From: Ian Hayward [REDACTED]
Sent: 23 November 2018 15:21
To: Richard Castro-Parker
Cc: Juan Baeza
Subject: RE: AB/73/18/PL -18 Queens Lane (land adjacent)

I am emailing regarding highways comments for application AB/73/18/PL -18 Queens Lane (land adjacent). While Highways have not been formally consulted I wondered if you would be able to comment on this application for 2 new dwellings. This application is being taken to Planning committee on the 12 Dec and as such I require comments before then so a committee update can be sorted out should one be required.

GROUND FLOOR PLAN - PROPOSED
SCALE 1:100

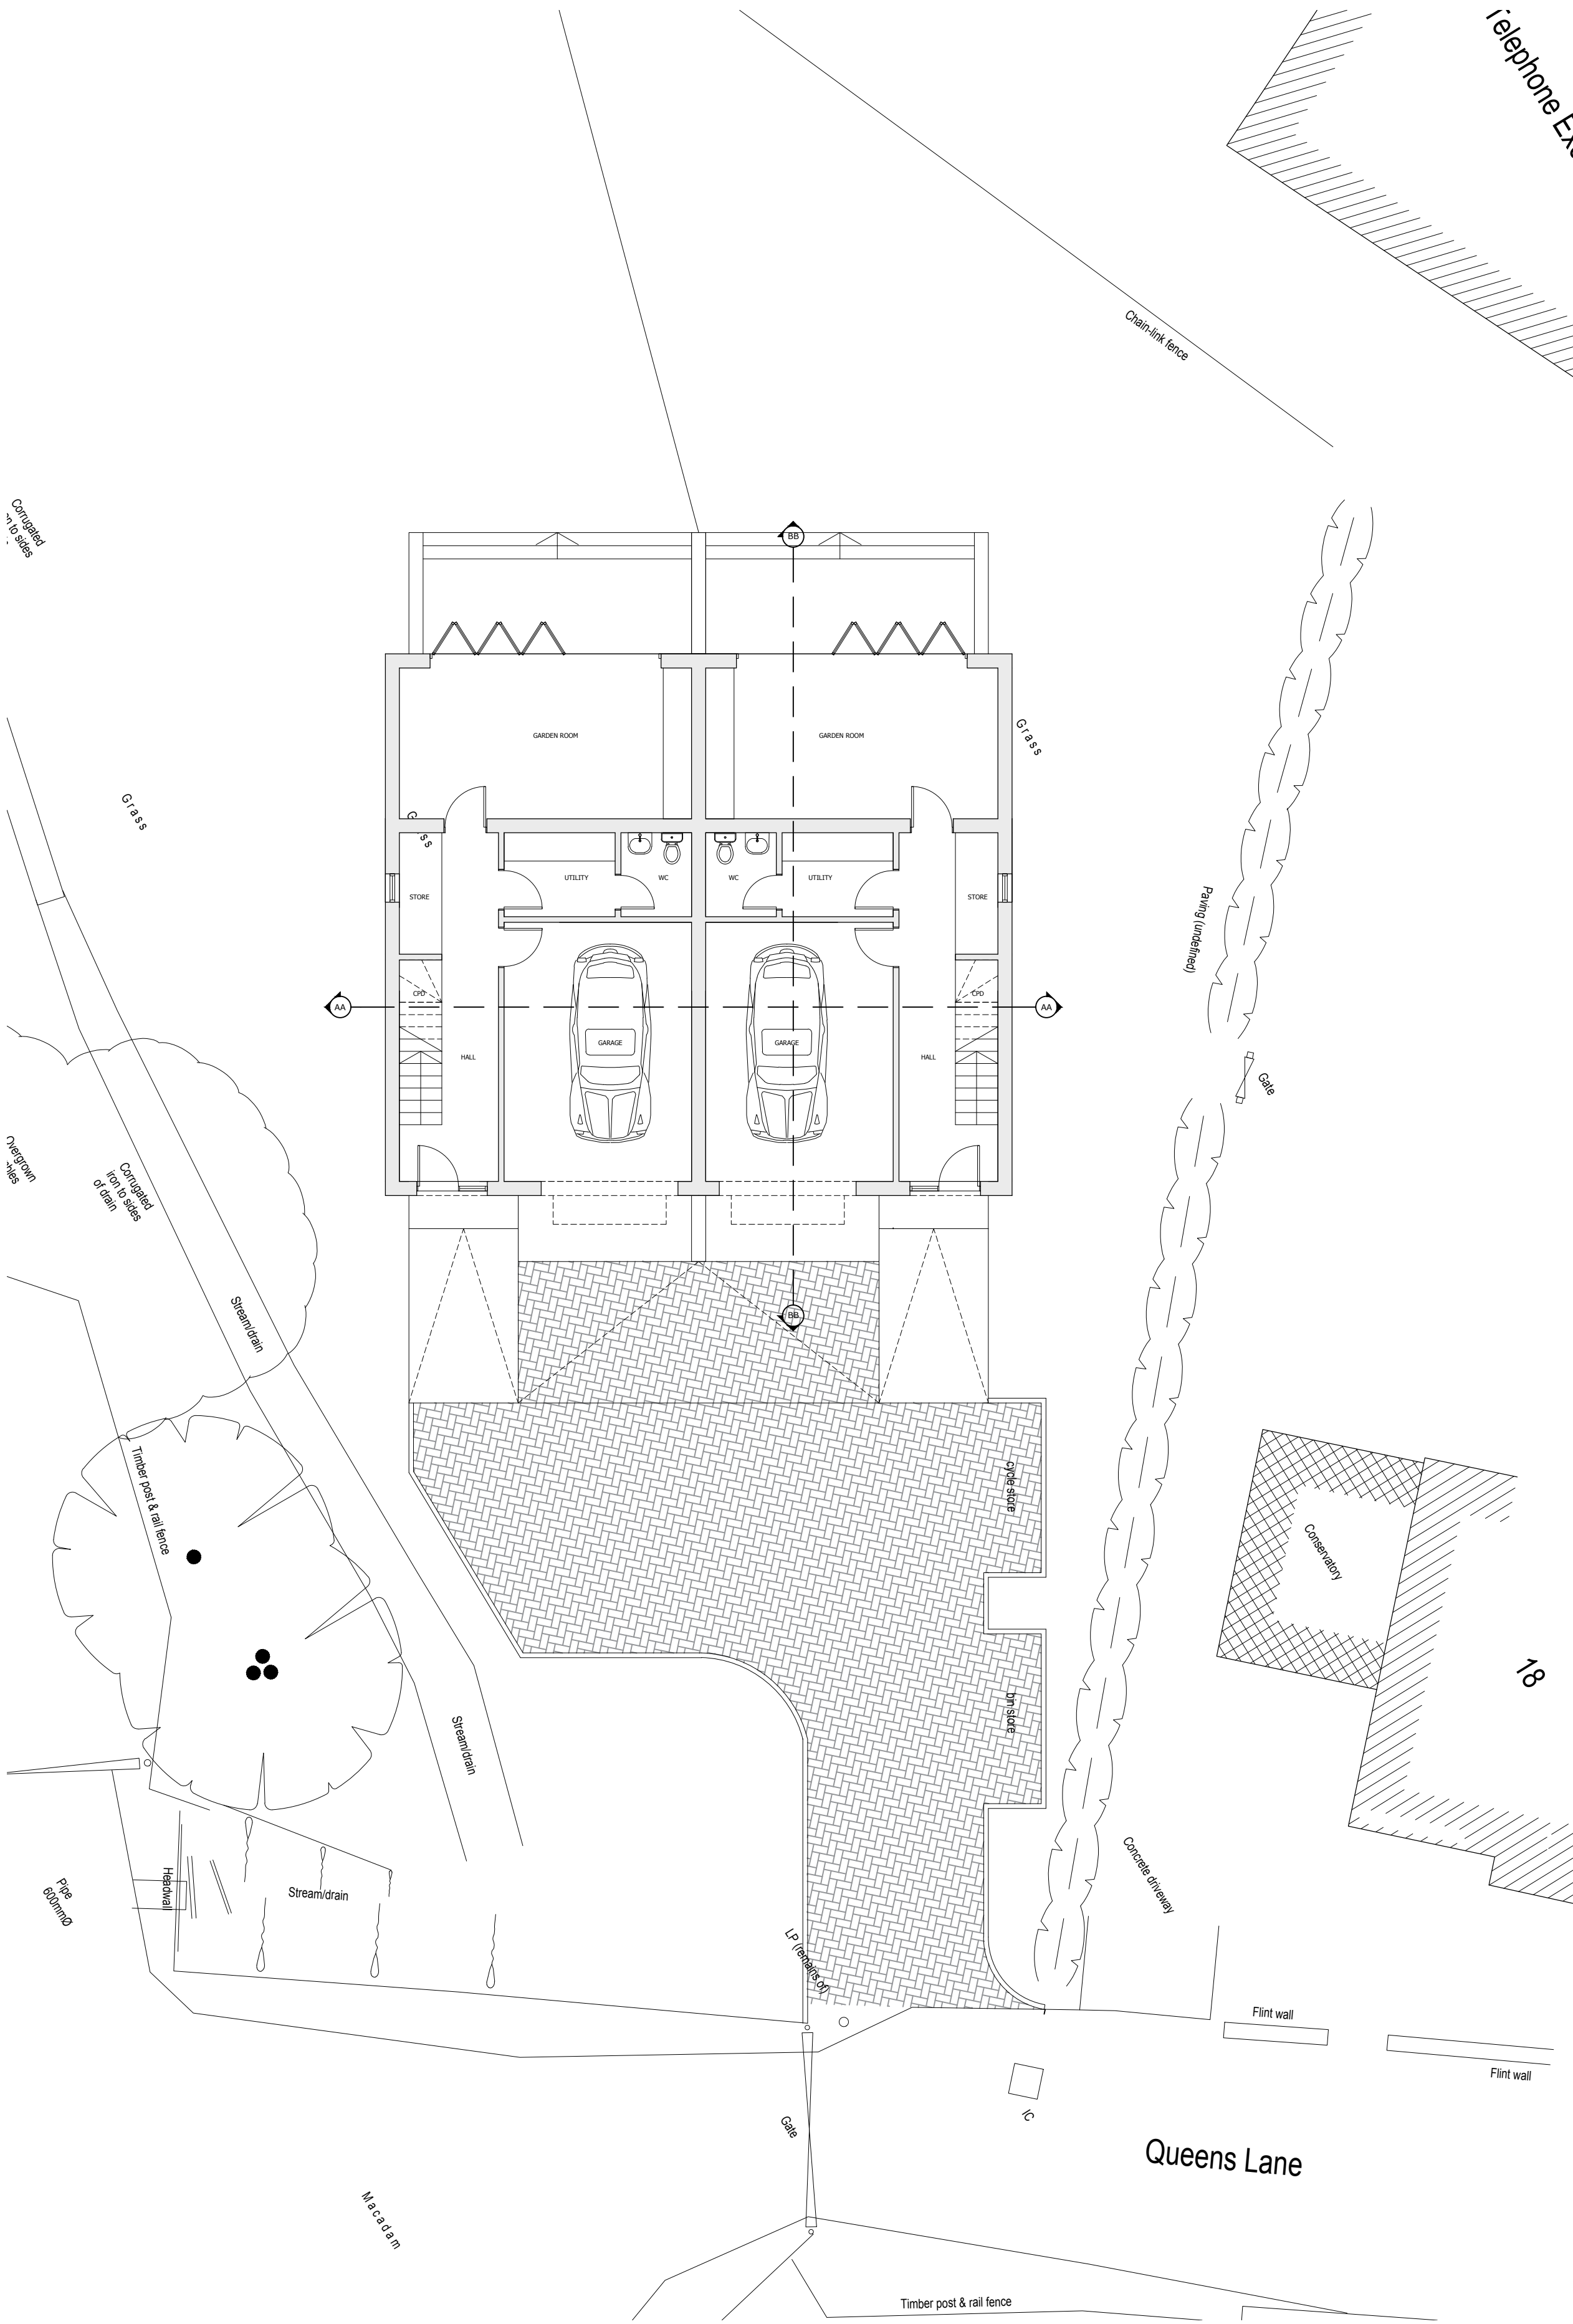
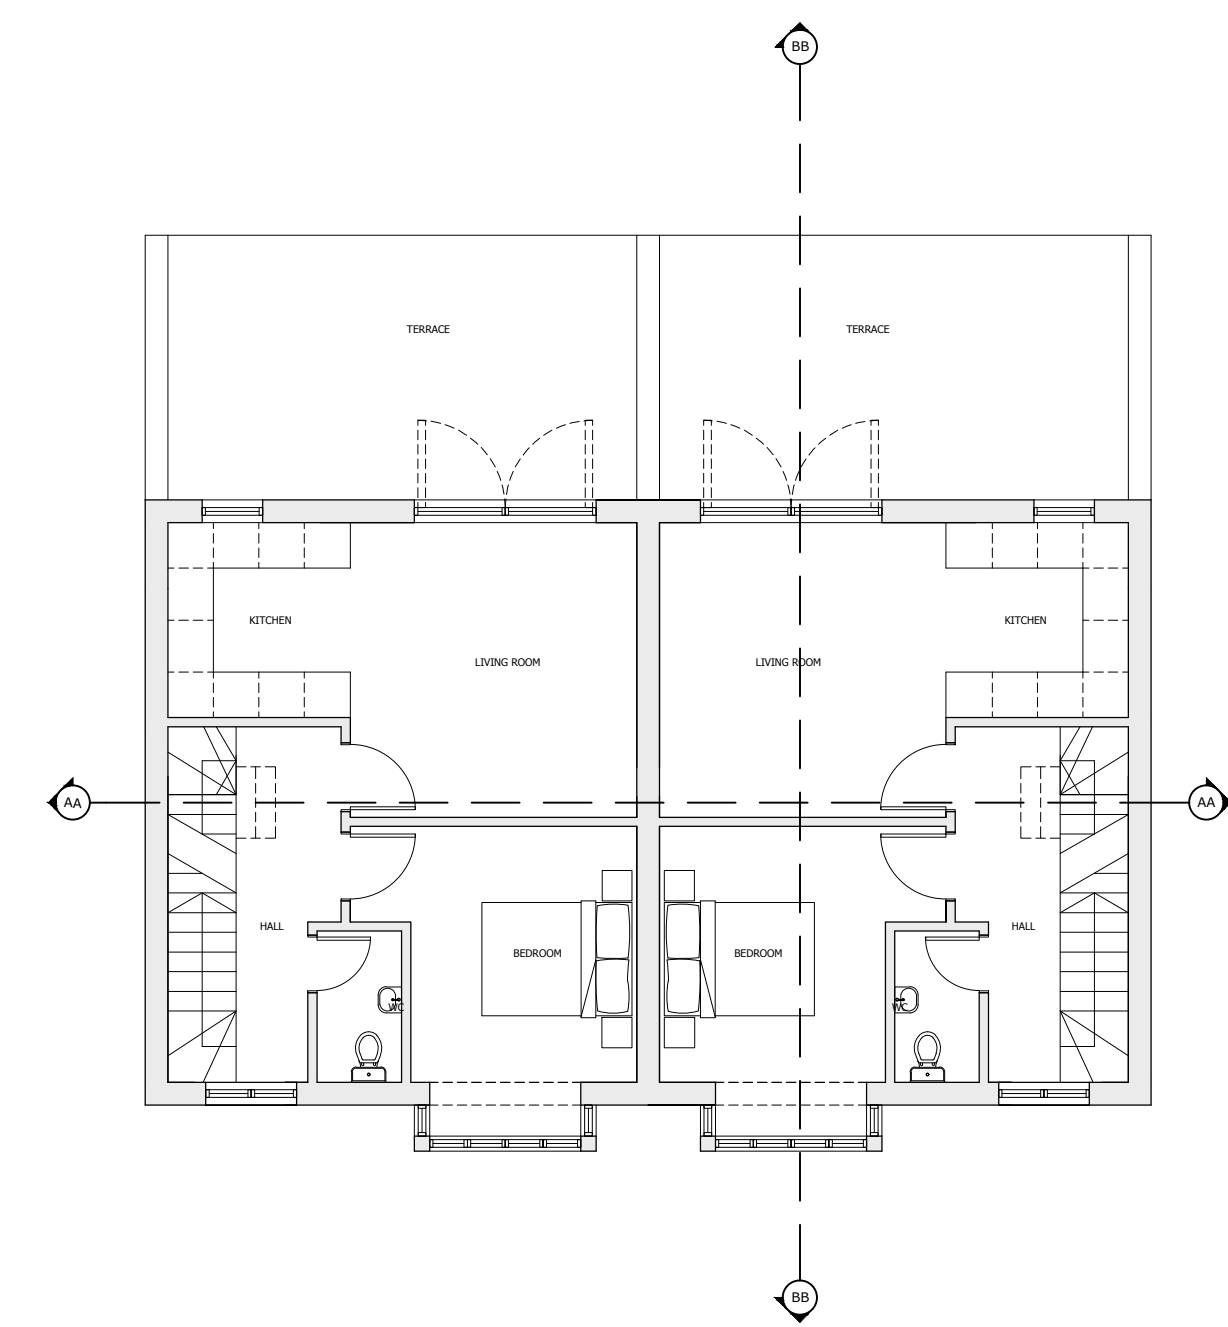
With regard to parking it seems each dwelling will be provided a single garaged space. Some shared hardstanding area is available but this would be required for turning and manoeuvring and therefore not ideal for providing allocated parking. WSCC advise garages measure a minimum of 3 x 6 metres to be considered allocated parking spaces, the proposed garages measure 4.3 x 5.5 metres. While this does not strictly meet the advised sizes I would be minded to accept that the actual floor area of garage proposed is of an adequate size to park a vehicle and cycle.

It would be anticipated that two dwellings of this size in this location would attract the demand for 4 car parking spaces. While the development is short 2 space I do not anticipate this to have any safety impact upon the maintained network and therefore would not raise this as a concern. You should consider the site is sustainably located within walking/cycling distance to a range of public services and amenities, access to other modes of transport for longer trips such as bus and train is achievable. As such a car parking provision below the anticipated demand should be generally considered acceptable. You may however wish to consider the implications the parking provision (and any resultant overspill parking) will have to the amenity of residents and neighbours.

If you are minded to grant planning consent a condition securing the garage provision for the parking of a vehicle and cycle would be advised.
